4 December 2012

DUBBO BASE HOSPITAL REDEVELOPMENT

Further to your letter dated 20 November 2012 in relation to the submissions received by your department during the exhibition of the proposed redevelopment, please find following our response to the traffic and transport related issues raised by each of the agencies and private party.

Figure 3.1 Proposed Redevelopment of Dubbo Base Hospital State Significant Development

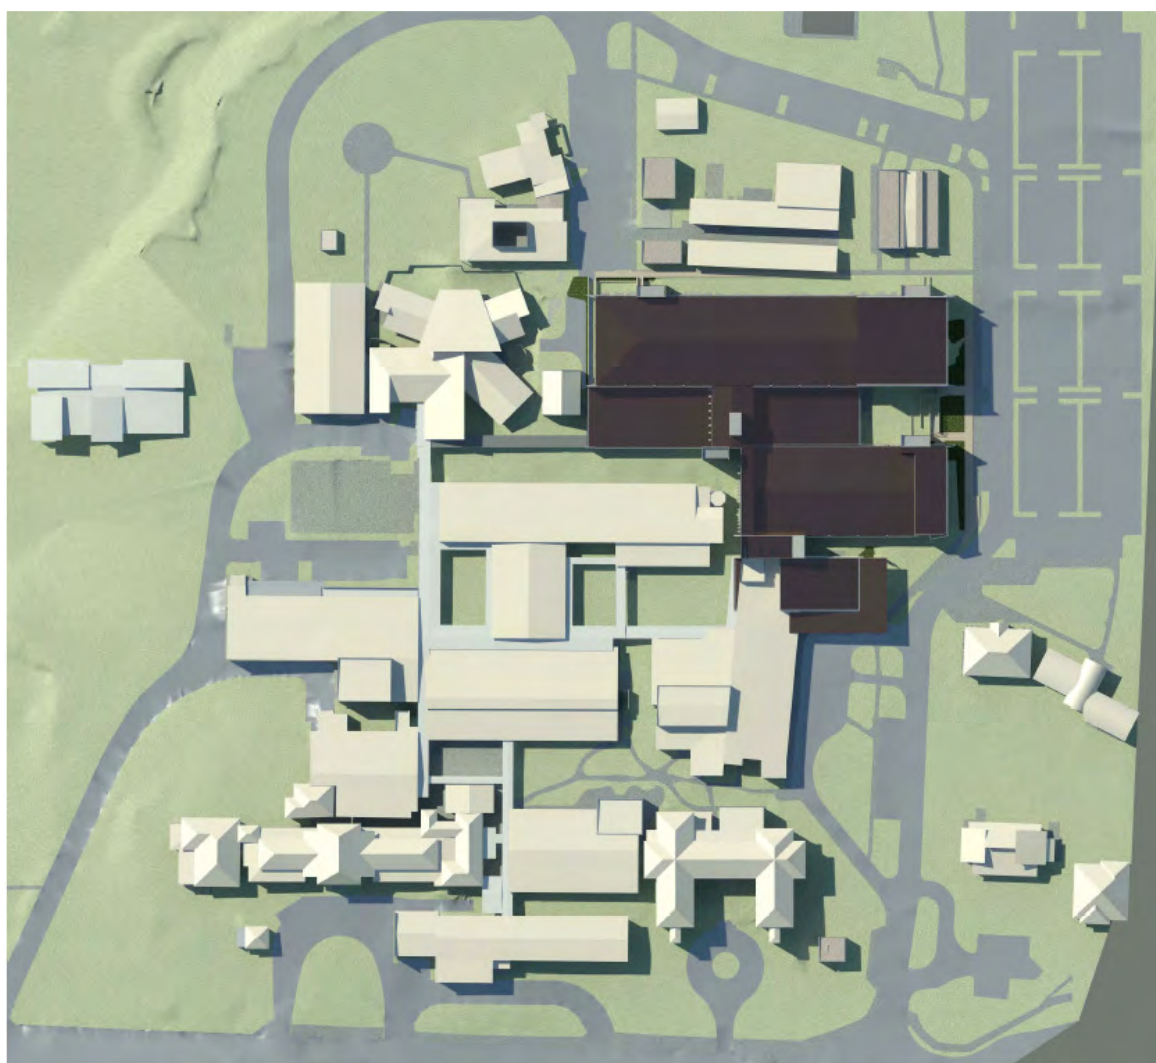
- ***'RMS recommends that the proponent consider providing additional onsite car parking spaces, as the parking survey indicates that weekday parking demand exceeds 400 cars from 9 am to 3.30 pm.'***

- ***'Existing parking on the land is proposed to increase with an additional 48 vehicle parking spaces. However, the parking analysis has not considered if the existing parking on the land was adequate and the overall demand of the hospital campus. It should also be noted that the EIS has contradictory statements in relation to parking spaces. They are stated as currently 350 (staff, patients & visitors) p.8, though the existing car park (augmented & regraded) to 289 spaces (net gain of 48 spaces) p.18 & p.36.'***

- ***'New car park is smaller than the existing one.'***

It is recognised that the surveys indicated that weekday demand for parking does exceed 400 spaces during the 9am to 3.30pm period. However, it should be noted that Hospital staff and visitors currently use both on-site and off-site parking spaces which have been identified in the Traffic Impact Assessment (TIA) and total 429 spaces. The key parking zones noted are the main on-site car park; Myall Street adjacent to the hospital site's southern end and a number of small on-site short-stay car parks.

The statutory assessment undertaken shows that the proposed net increase of 48 on-site car parking spaces meets the requirements for the proposed Hospital extension as set out in Dubbo City Councils' Local Environmental Plan (LEP). The application does not seek to specifically address any parking issues as a result of extant planning permission for the Hospital. However, with the demolition of the maternity building there is potential for an additional 37 car parking spaces to be provided above what is required to help contribute to alleviating any existing deficiencies in parking supply.

By way of clarification, as part of the proposed redevelopment the main car park is to be upgraded and expanded to provide a total of 289 spaces. This represents an increase of 48 spaces from the current 241 spaces (235 in the main car park and 6 adjacent to the oncology building). Both on-site and off-site parking spaces have been identified in the Traffic Impact Assessment (TIA). The key existing parking zones noted on-site is the main car park and a number of small short-stay car parks which total 329 spaces.

The additional car parking spaces (potentially 37 spaces) to be provided following the demolition of the maternity building will help contribute to alleviating any existing deficiencies in parking supply.

As part of the proposed redevelopment the main car park is to be upgraded and expanded to provide a total of 289 spaces. This represents an increase of 48 spaces from the current 241 spaces (235 in the main car park and 6 adjacent to the oncology building).
